Application for a non-material amendment following a grant of planning permission.

Demolition and erection of 1 No. dwelling

Reference number: M/84/18/PL

6. Non-Material Amendment(s) Sought

PROJECT TITLE		DRAWING TITLE		No	REVISION	DATE
Proposed Development at 24 Alleyne Way, Bognor Regis		Proposed Elevations				
		STATUS	Non material amendment			
		SCALE	1:100 @ A3			
		DATE	26.03.2019			
		DRAWN BY	AP			
		DRAWING No	NM-248-09

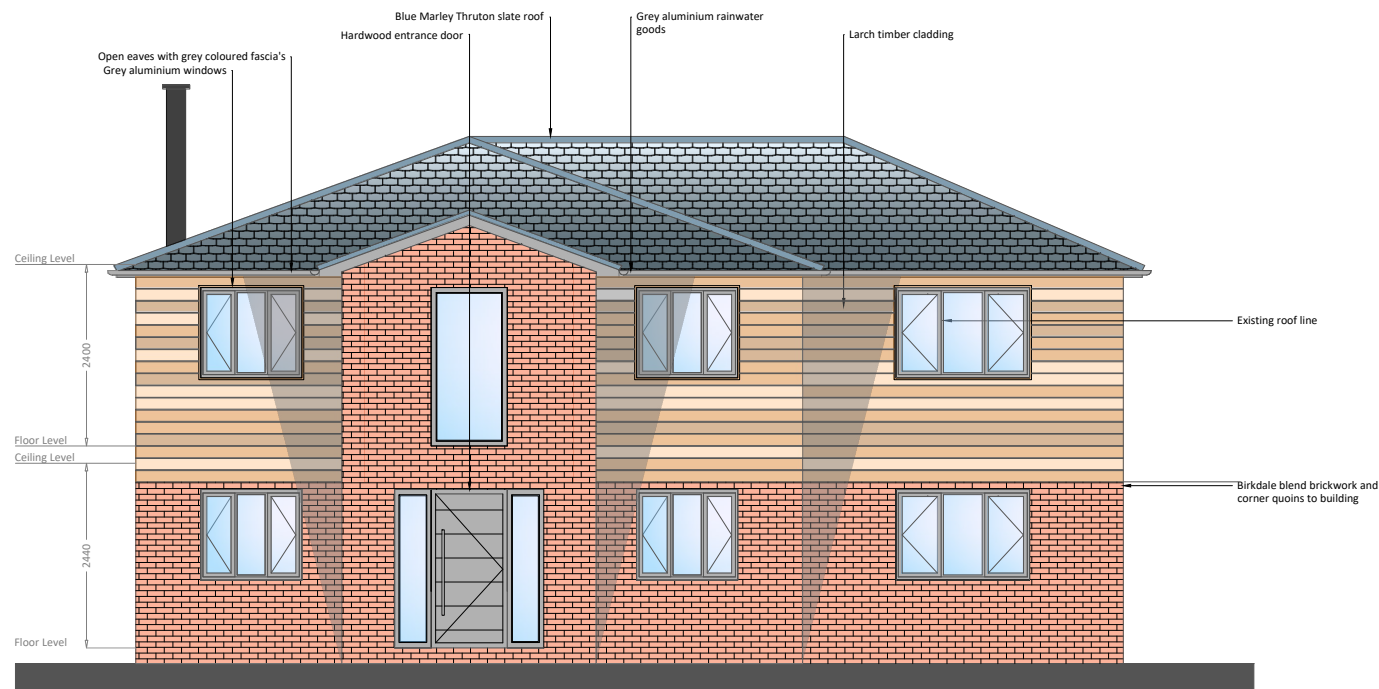
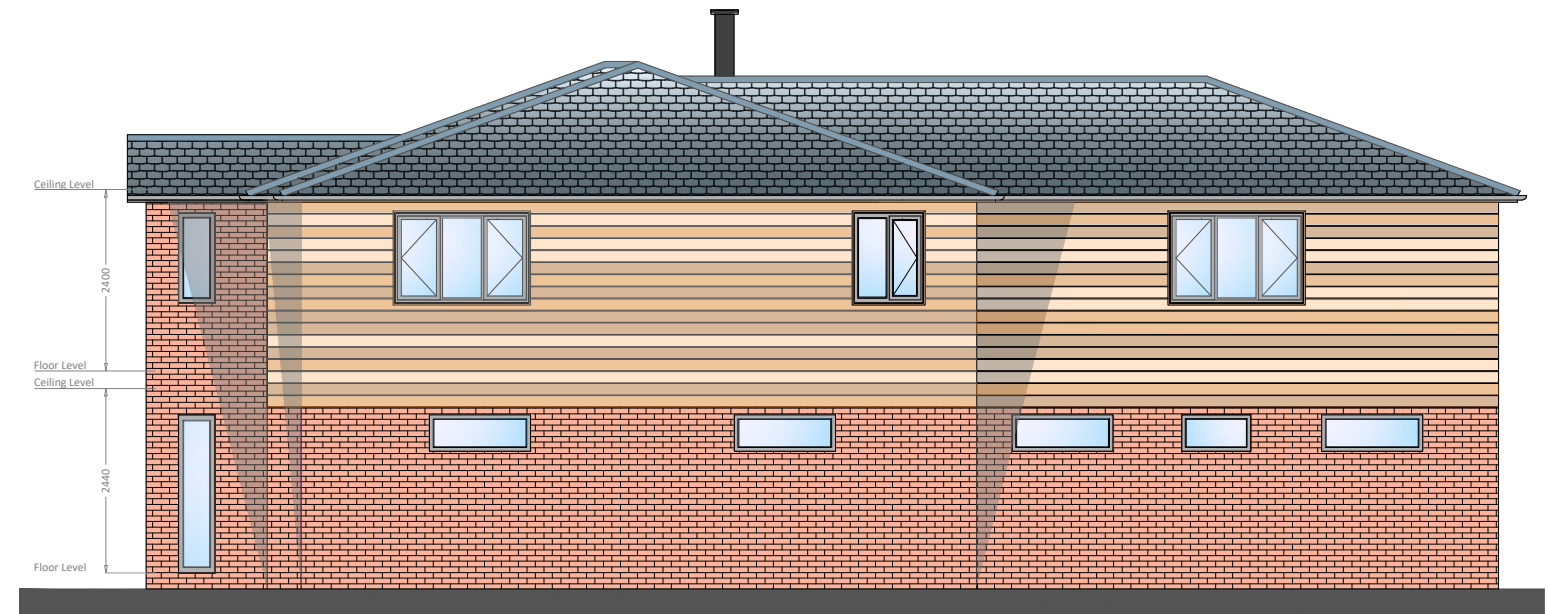
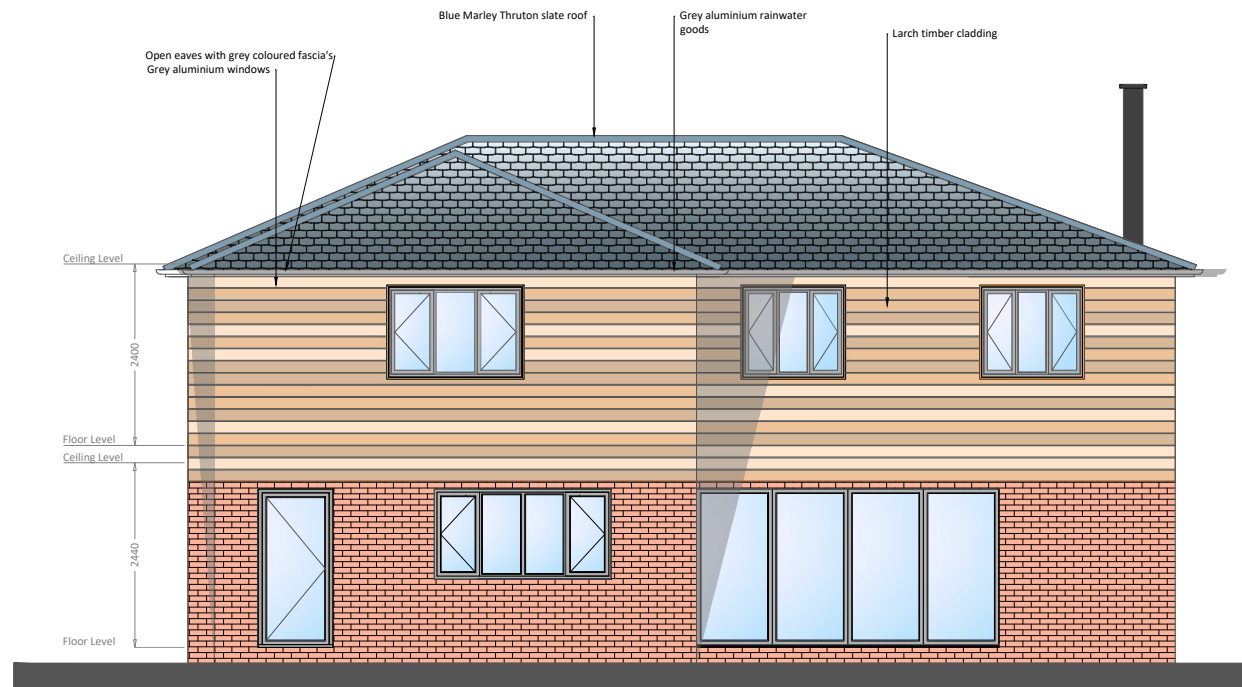
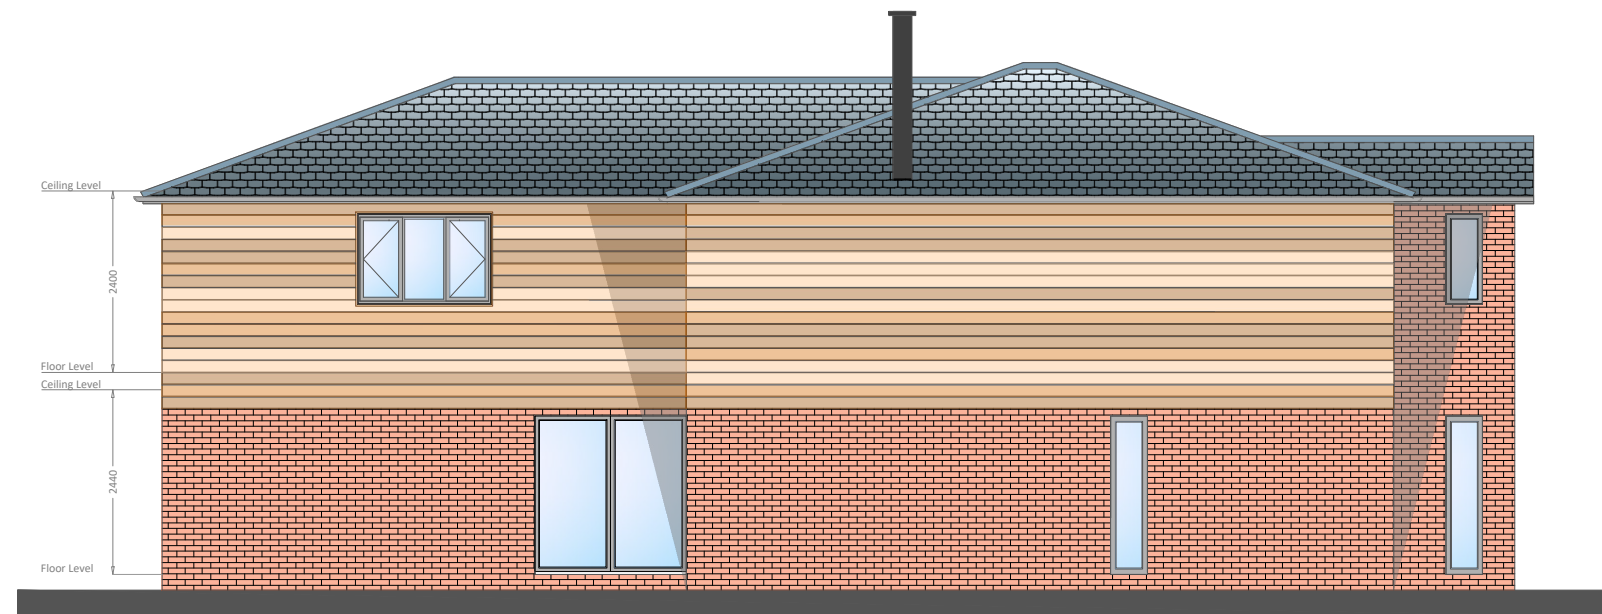
Due to advice from the structural engineer the brick piers originally planned for the first floor elevations are not safe to construct, therefore please see attached elevation plans showing the cladding continuing around the first floor elevations apart from the front protruding area which will be brickwork. Following the Environment Agency implementing the finished floor level having to be 300mm above the existing finished floor level making the AOD 4.01m (condition 7) the height of the new dwelling will be 7.3 metres in height.
